Subject: Eagle Rising SF2225 Plat Filing 1 Response Letter and EDARP Upload

Our responses to the EPC August 15, 2024 Plat and related documents review comments and the Applicant team and EPC staff September 4, 2024 review meeting have been uploaded EDARP.

Submittal N	EDARP Review Comments	8.15.2024	Applicant Response spreadsheet Date	9.10.2024														
Project Name	Eagle Rising Final Plat Filing No. 1 (Minor) SF2225

EAGLE RISING FILING NO. 1
 A PORTION OF THE EAST HALF (E1/2) OF SECTION 29, TOWNSHIP 12 SOUTH,
 RANGE 65 WEST OF THE SIXTH PRINCIPAL MERIDIAN, EL PASO COUNTY, COLORADO

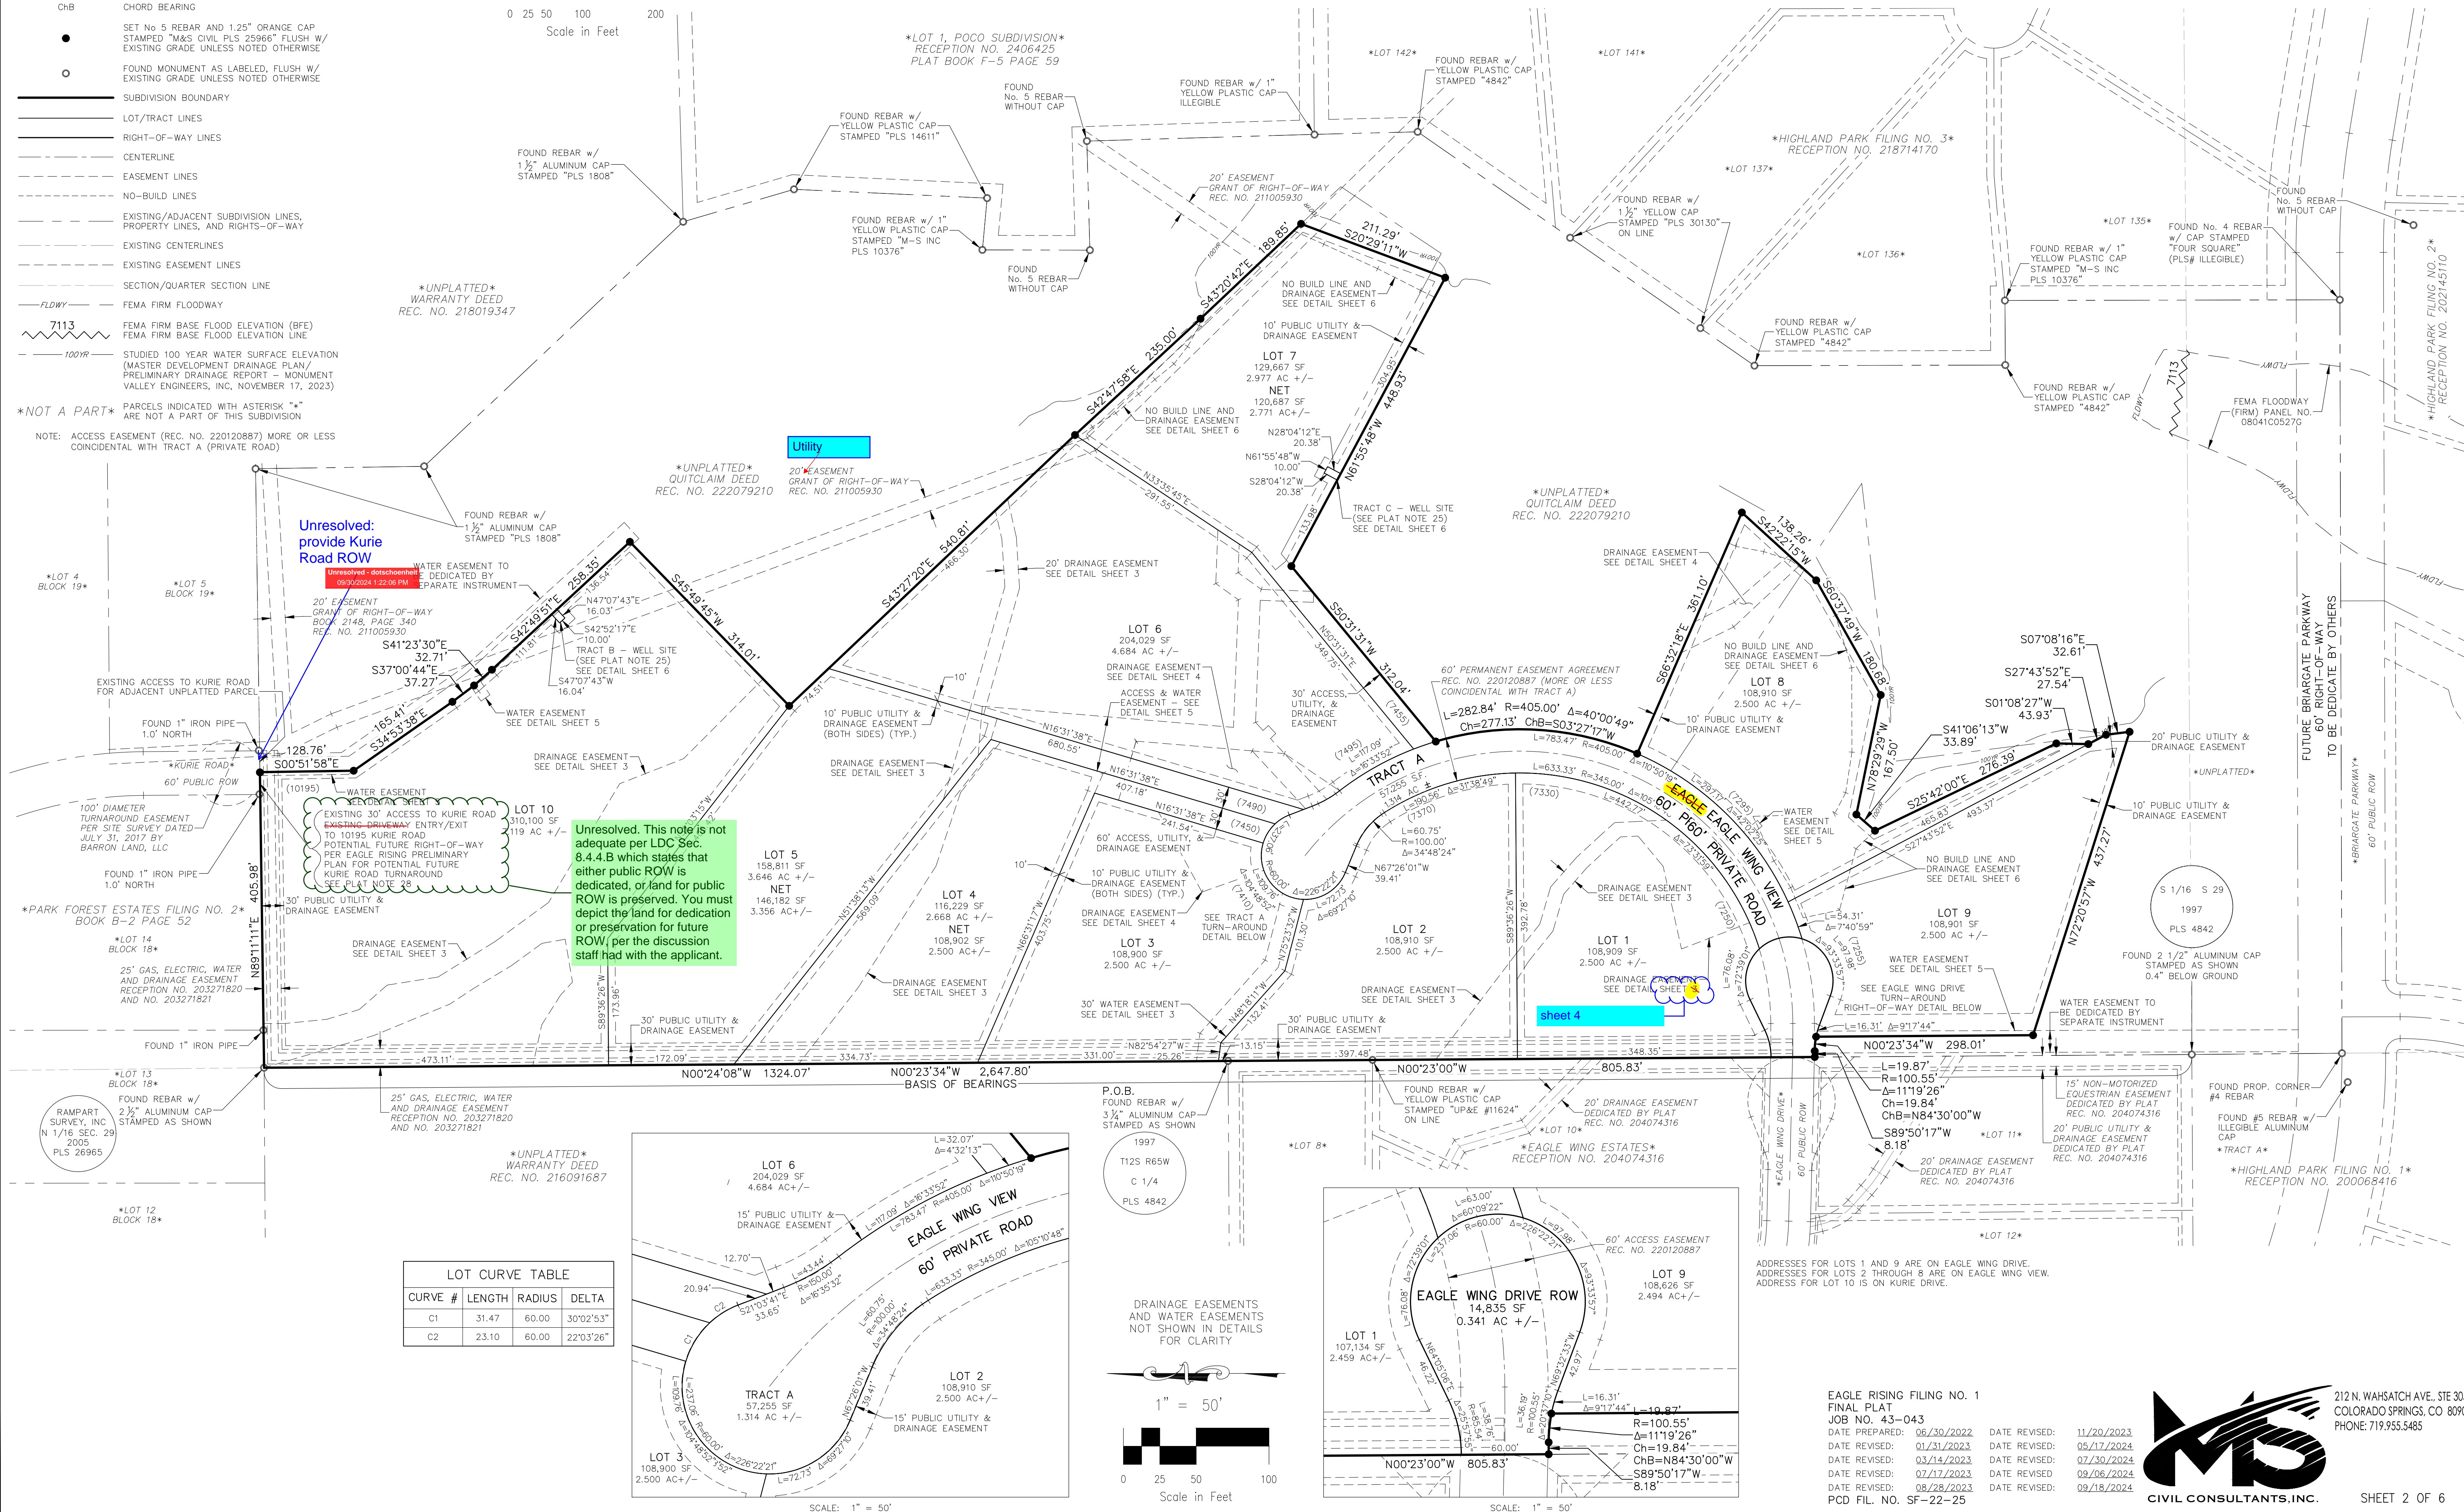
7	Final Plat Eagle Rising Filing No 1	PCD Engineering Division	Yes	Jeff Rice	8/15/2024 16:12	(Plat redlines)	1	Note 28. This does not meet the requirement to provide the Kurie Road ROW.	E - Answer provided	9/17/2024	Final Plat Eagle Rising Filing No 1	-	Disagree					
8	Final Plat Eagle Rising Filing No 1	PCD Project Manager	Yes	Ryan Howser	8/15/2024 16:12	(Plat redlines)	1	The dates and commitment no. will need to be updated when the plat is recorded to reflect the new title commitment. This is especially important if the external boundary of the subdivision is changing.	A - Approve	9/17/2024	Final Plat Eagle Rising Filing No 1	-	Agree before recording.					
9	Final Plat Eagle Rising Filing No 1	PCD Project Manager	Yes	Ryan Howser	8/15/2024 16:12	(Plat redlines)	1	Note 18. Please address the Colorado Geological Survey comments on Note 18 by providing for mitigation measures. Staff recommends updating the highlighted part to state that basements are prohibited.	E - Answer provided	9/17/2024	Final Plat Eagle Rising Filing No 1	-	See updated Note 18.

20	Final Plat Eagle Rising Filing No 1	PCD Engineering Division	Yes	Jeff Rice	8/15/2024 16:12	(Plat redlines)	2	Unresolved: provide Kurie Road ROW	C - Disapproved	9/17/2024	Final Plat Eagle Rising Filing No 1	-	Disagree					
21	Final Plat Eagle Rising Filing No 1	PCD Engineering Division	Yes	Jeff Rice	8/15/2024 16:12	(Plat redlines)	2	call out access easement to Lot 7	A - Approve	9/17/2024	Final Plat Eagle Rising Filing No 1	4	See updated Access & Water Easement Detail					
22	Final Plat Eagle Rising Filing No 1	PCD Engineering Division	Yes	Jeff Rice	8/15/2024 16:12	(Plat redlines)	2	per discussions, the lots are to be 15' from the floodplain or will require an agreement for maintenance access to the drainageway	C - Disapproved	9/17/2024	Final Plat Eagle Rising Filing No 1	-	Lots are already 15' outside 100 year water elevation. Jeff Rice error.					
23	Final Plat Eagle Rising Filing No 1	PCD Engineering Division	Yes	Jeff Rice	8/15/2024 16:12	(Plat redlines)	2	Include both owners on title page and in agreements	C - Disapproved	9/17/2024	Final Plat Eagle Rising Filing No 1	-	IQ Investors LLC is not party to Eagle Rising Final Plat Filing No. 1

DRAINAGE EASEMENT DETAILS
 LOTS 3 & 6
 SCALE: 1" = 50'

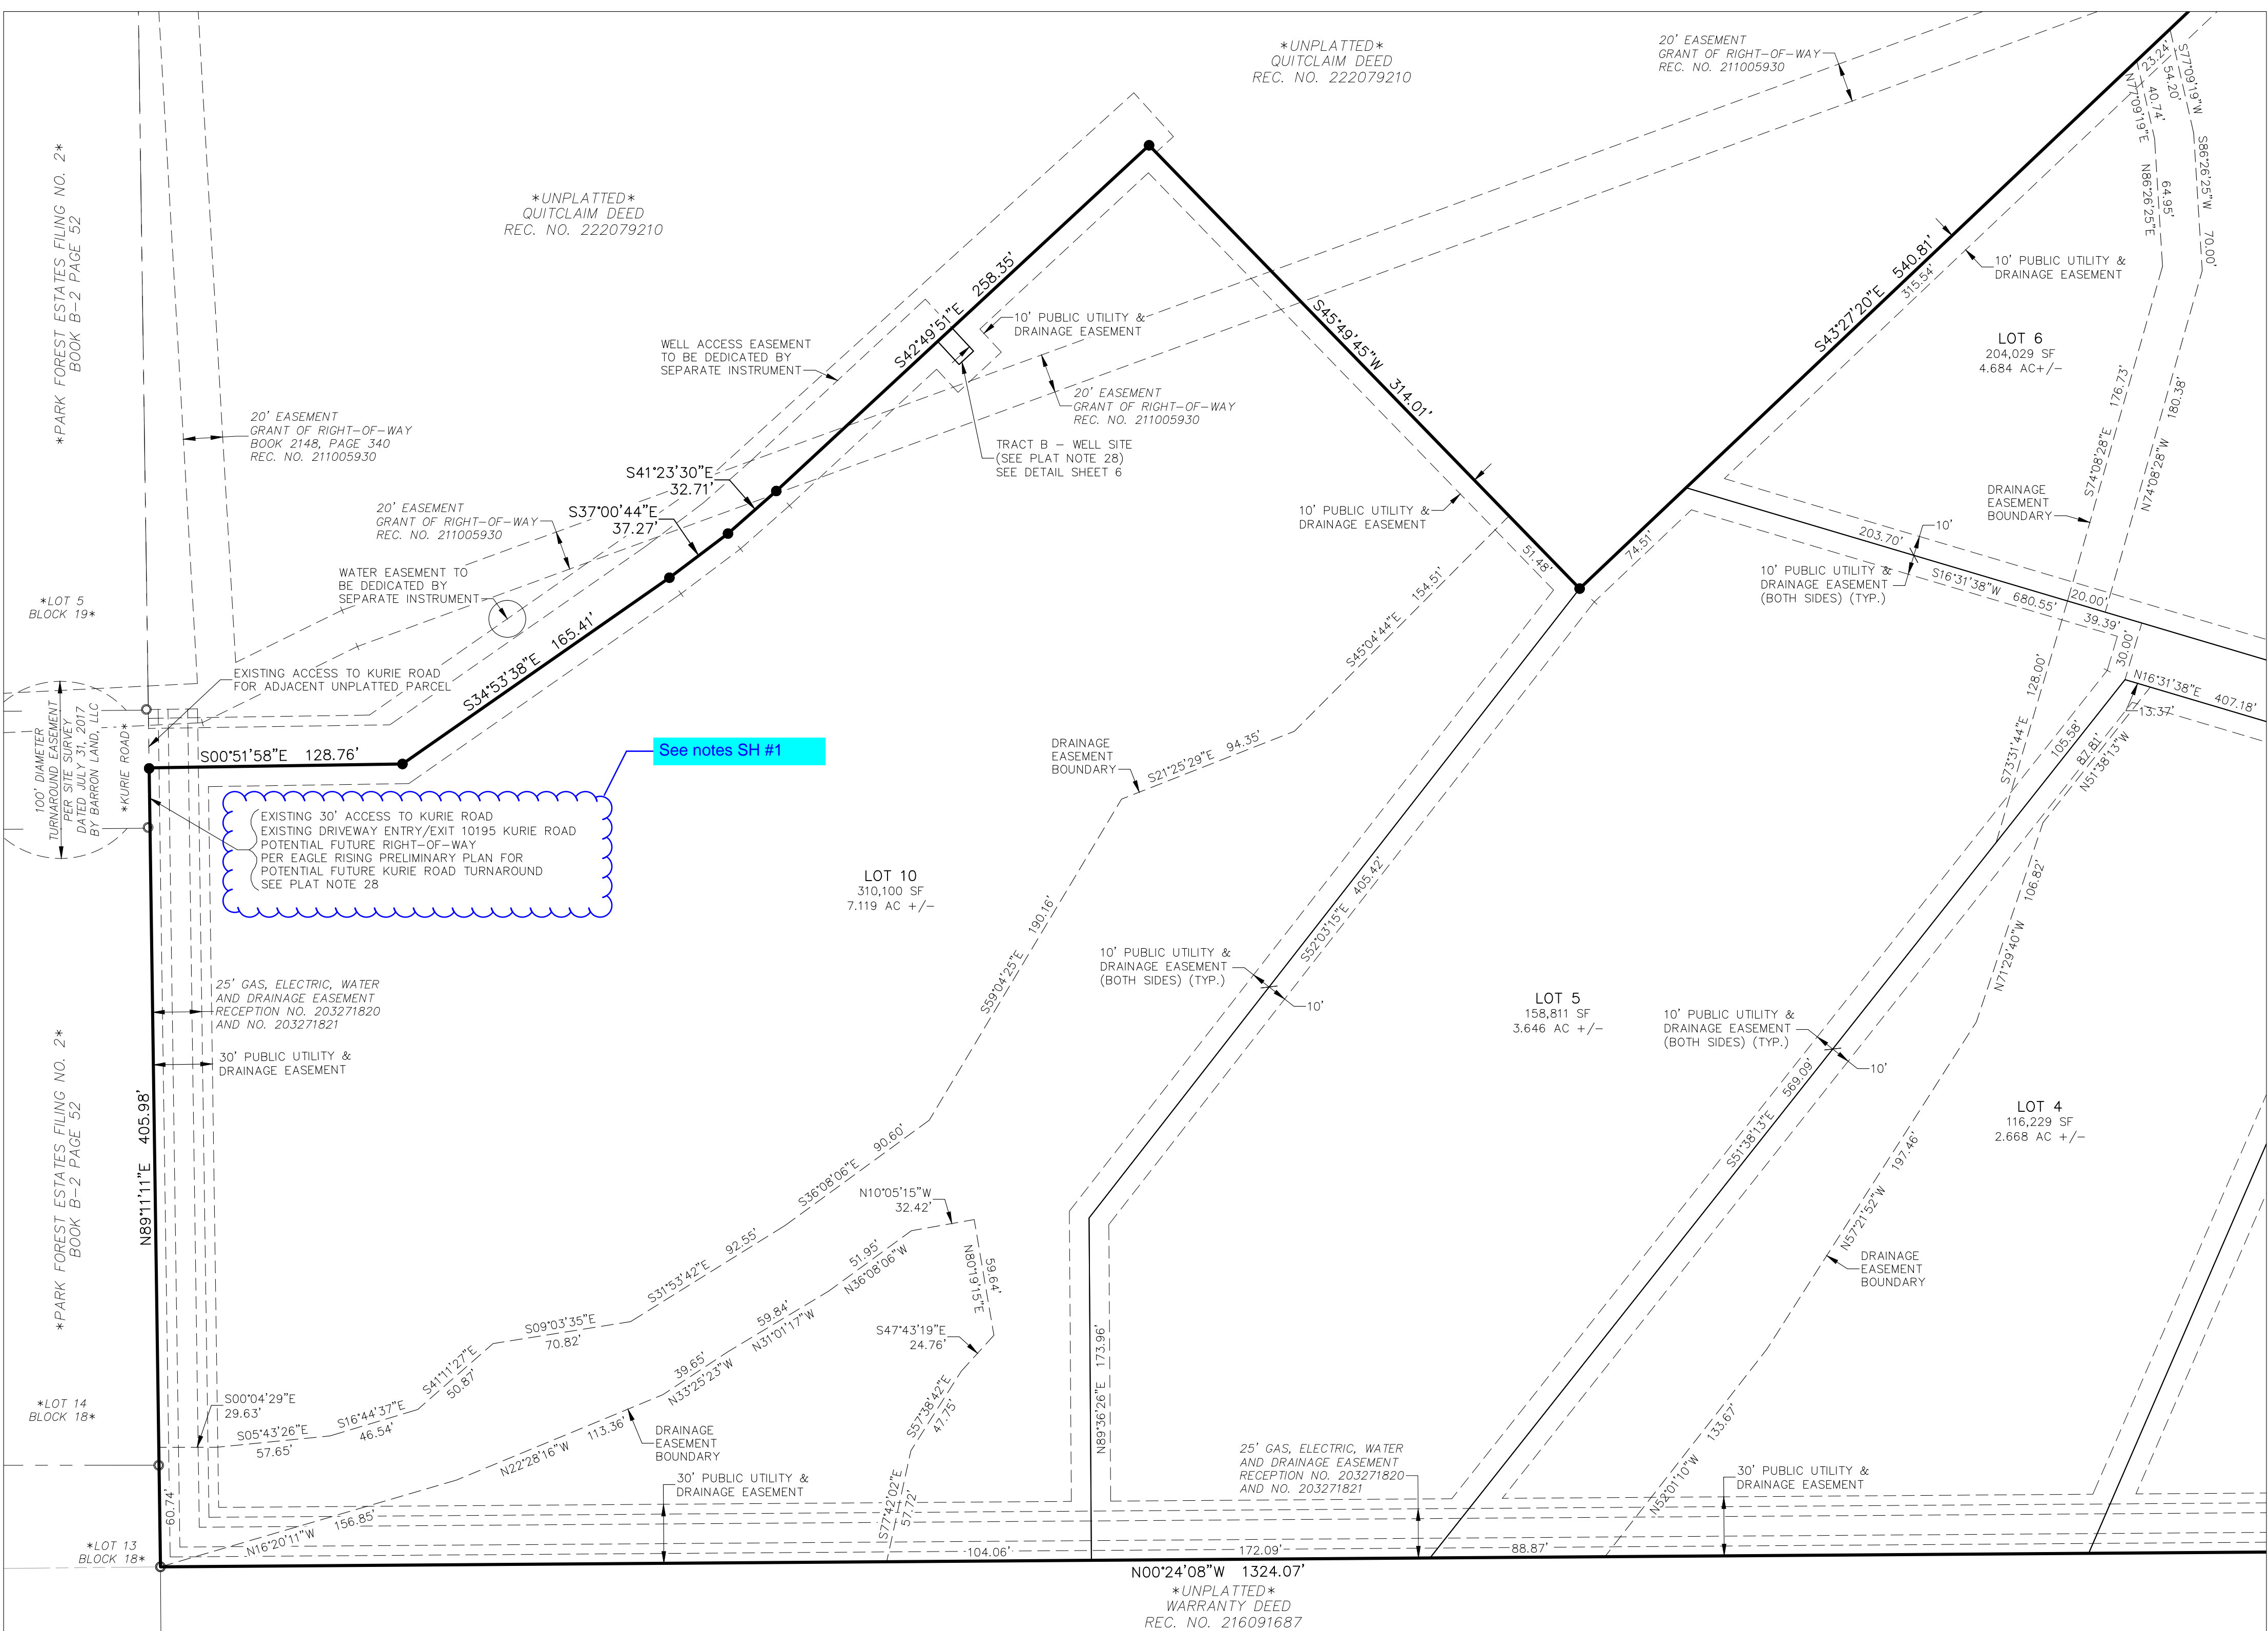
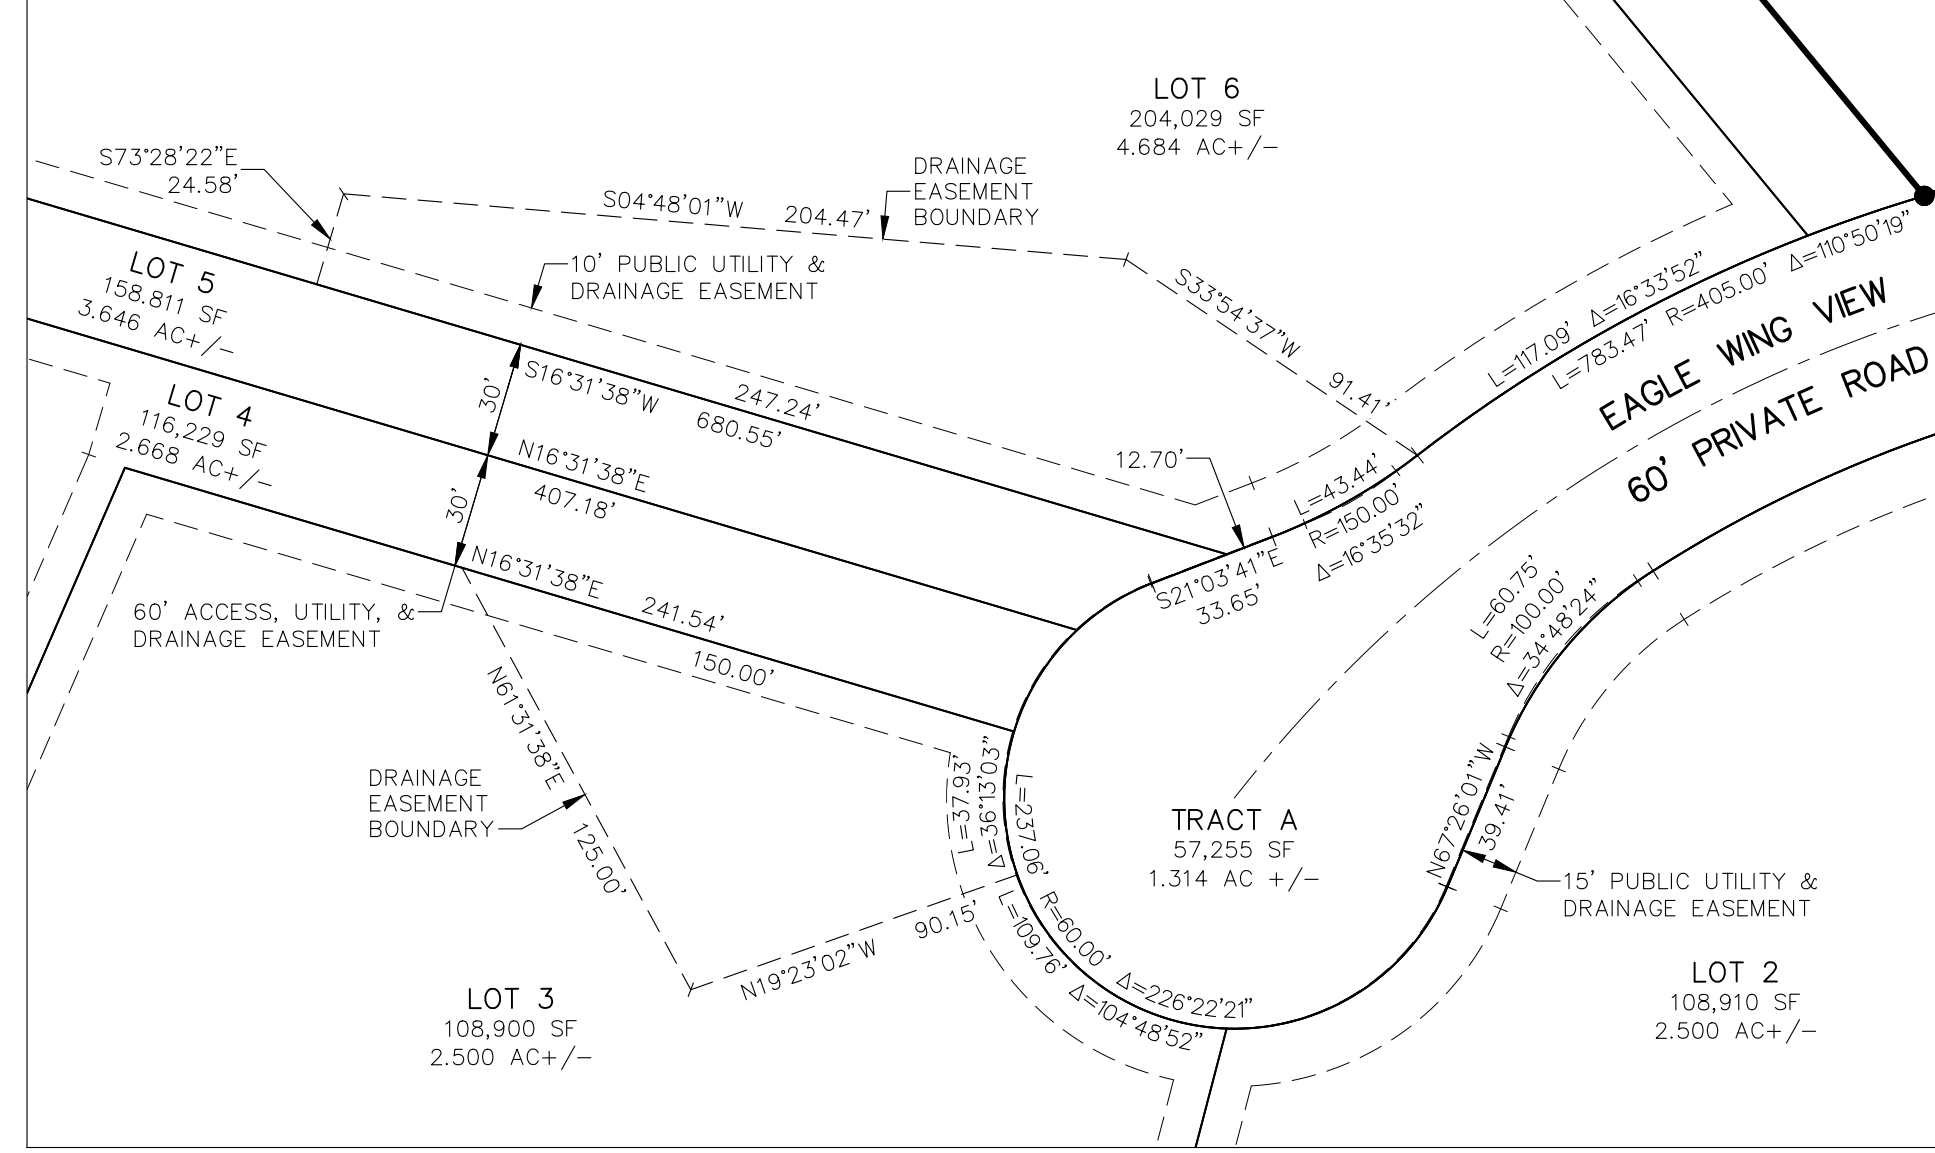
24	Final Plat Eagle Rising Filing No 1	PCD Engineering Division	Yes	Jeff Rice	8/15/2024 16:12	(Plat redlines)	2	provide drainage easement	A - Approve	9/17/2024	Final Plat Eagle Rising Filing No 1	4	Added					
25	Final Plat Eagle Rising Filing No 1	PCD Engineering Division	Yes	Jeff Rice	8/15/2024 16:12	(Plat redlines)	2	Provide drainage easement per FDR comments	A - Approve	9/17/2024	Final Plat Eagle Rising Filing No 1	5	Added					
26	Final Plat Eagle Rising Filing No 1	PCD Engineering Division	Yes	Jeff Rice	8/15/2024 16:12	(Plat redlines)	2	Is property boundary going to be adjusted prior to platting?	E - Answer provided	9/17/2024	Final Plat Eagle Rising Filing No 1	-	Boundary lines will be adjust prior to recording after Final Plat approval .					
27	Final Plat Eagle Rising Filing No 1	PCD Engineering Division	Yes	Jeff Rice	8/15/2024 16:12	(Plat redlines)	2	label acreage	A - Approve	9/17/2024	Final Plat Eagle Rising Filing No 1	2	Added

45	Eagle Rising Filing No 1 Final Drainage Report	PCD Engineering Division	Yes	Jeff Rice	6/6/2024 10:41	(FDR redlines)	212	Provide drainage easement and analysis based on revisions to report	E - Answer provided	9/17/2024	Eagle Rising Filing No 1 Final Drainage Report	-	Added Drainage easement and coordinated with plat drawing
